PINS ref: EN010170

Application by Green Hill Solar Farm Ltd. for an Order granting Development Consent for a proposed solar development on land between Northampton and Wellingborough

**CPRE Northamptonshire
Summary Statement
Deadline 7, 8th April 2026**

Title: Figure 8.6.4 Landscape Receptors
Green Hill F & BESS

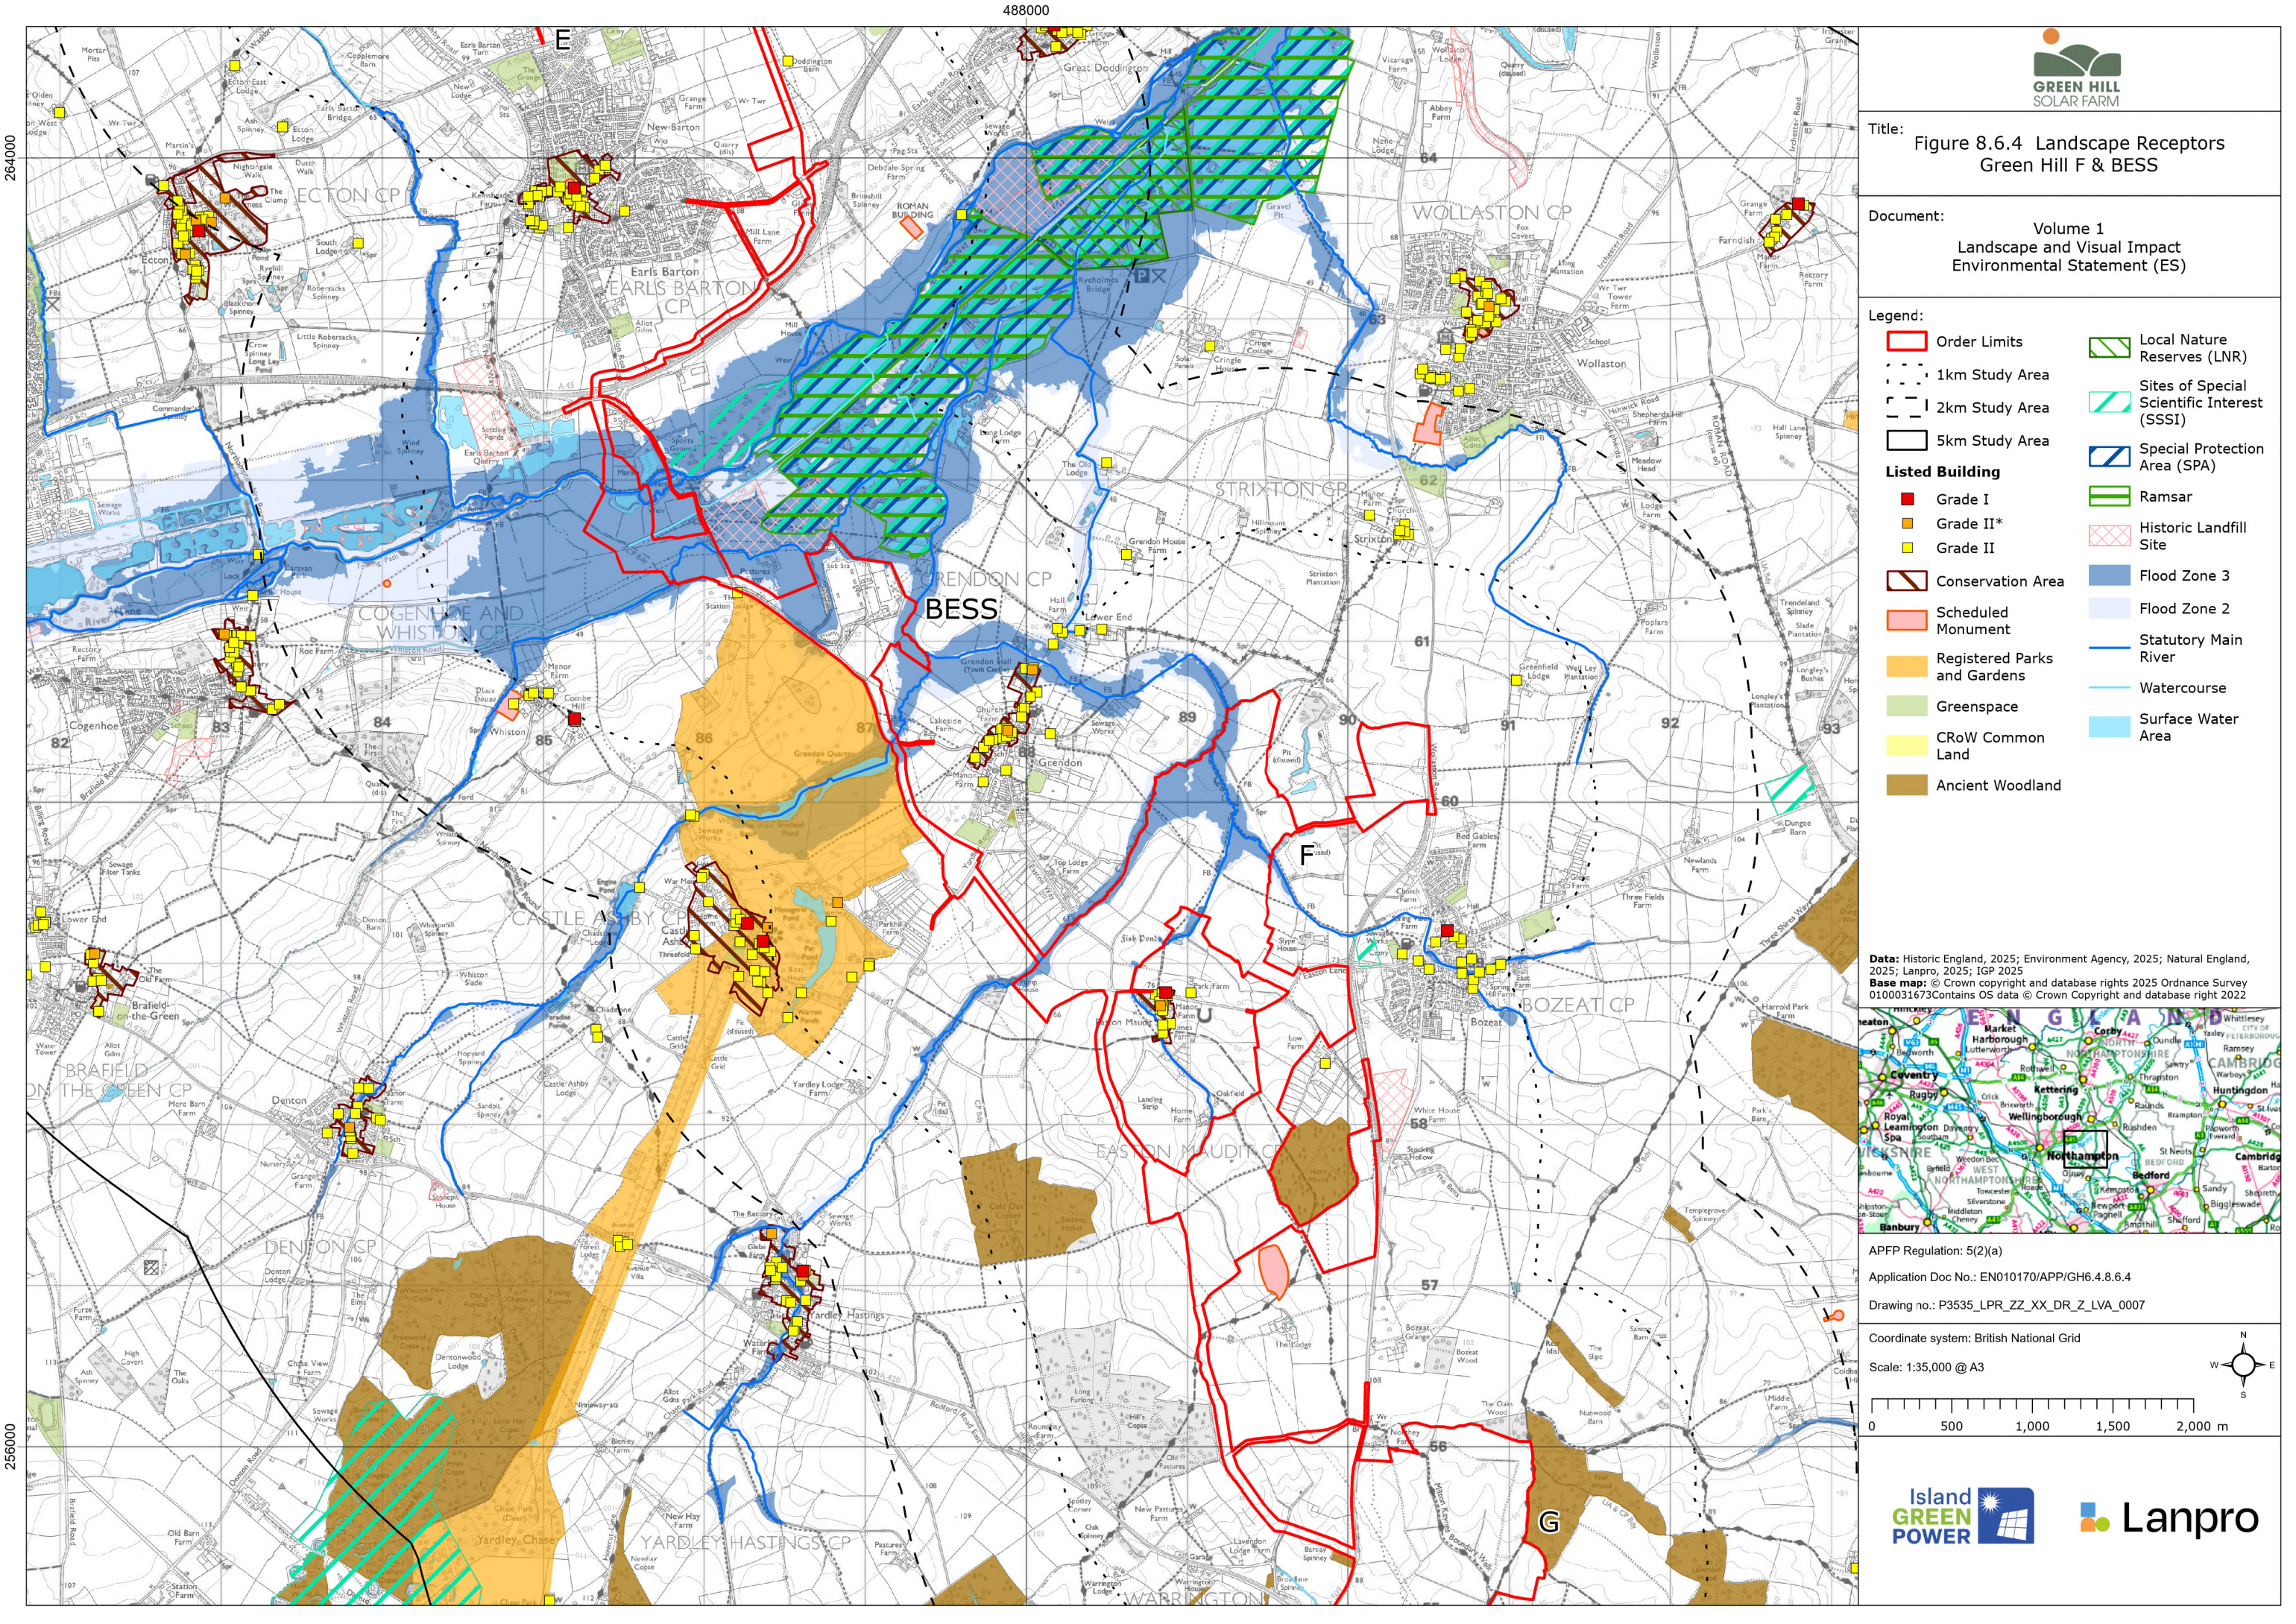
1. The Grendon BESS is very close to both residential and business premises. It is not unlikely that a fire would require an evacuation of the village and other nearby premises but no refuge is identified that could accommodate the significant numbers that would need to be evacuated.

3. The Grendon BESS is proposed on a floodplain which would not normally be considered a suitable location for such infrastructure. It is proposed to elevate the BESS but there is no certainty that the measures proposed would be adequate to prevent flooding in the long term should flood levels increase.

Title: Figure 8.10.3 Viewpoint Locations
Green Hill C, D & E

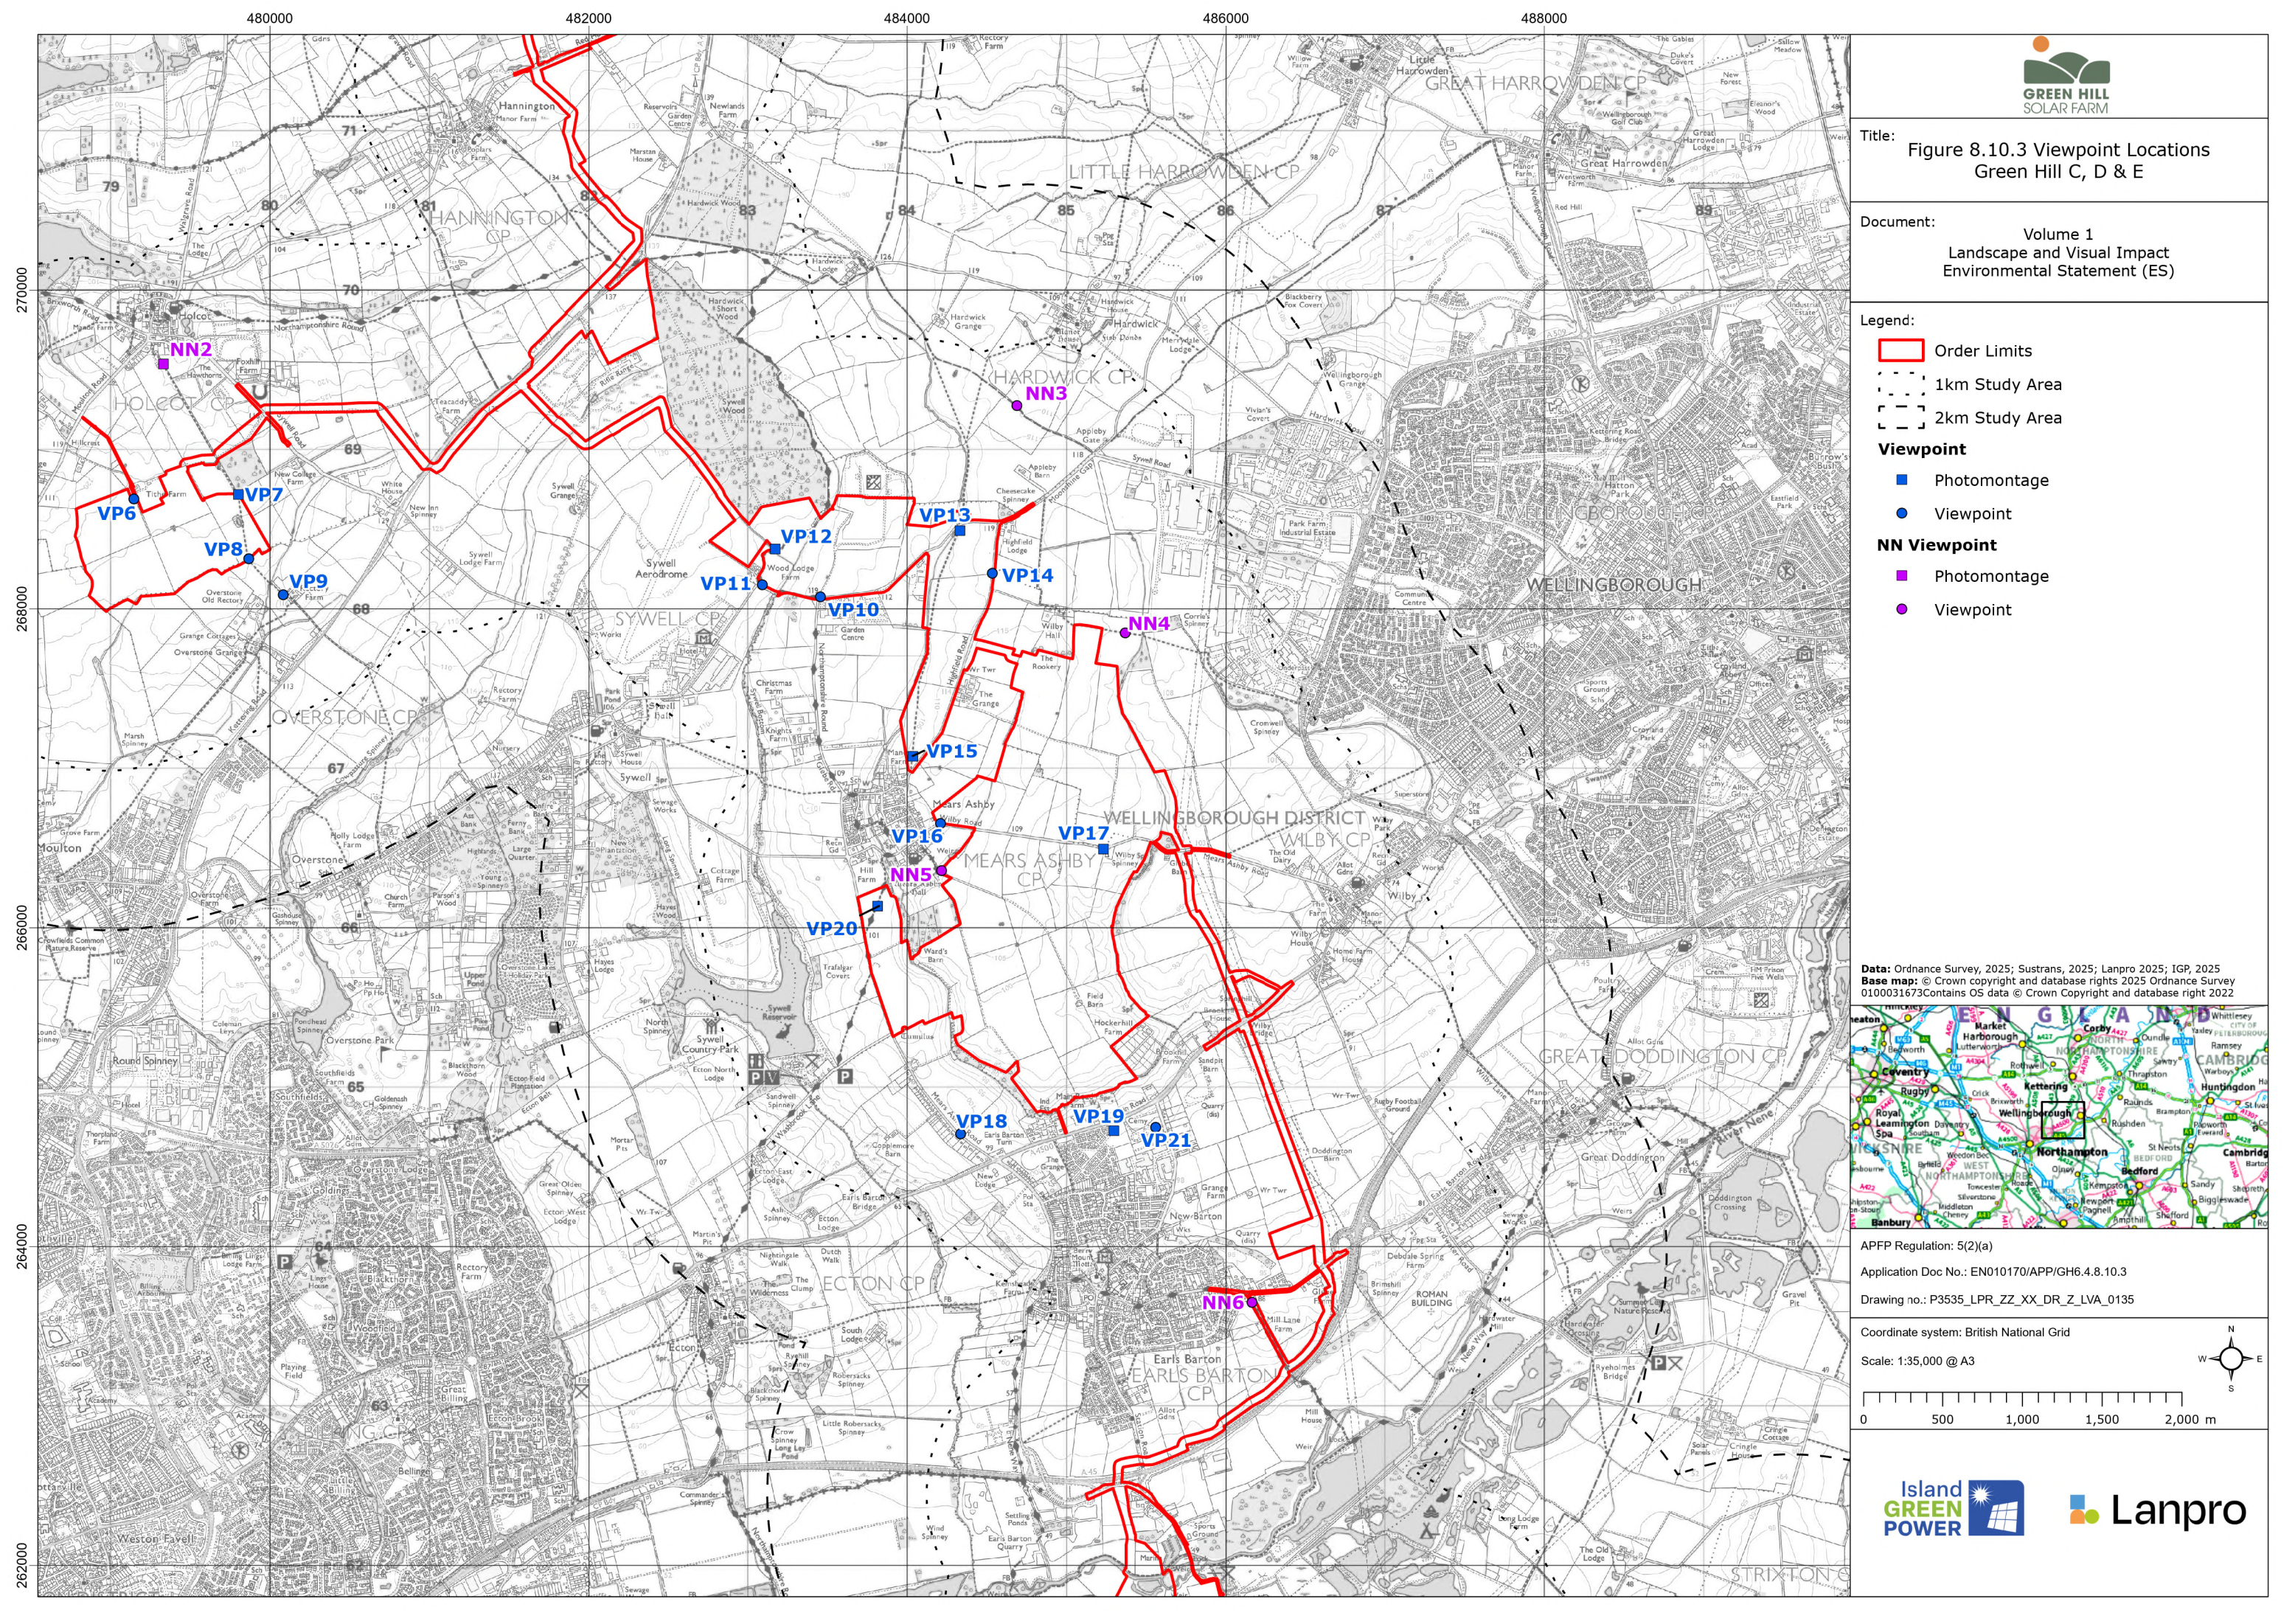
2. The viewpoint selection was agreed with the LPAs before the layout of the panels was disclosed which compromised their value
3. The methodologies used frequently result in lower assessments of harm than those used in comparable applications
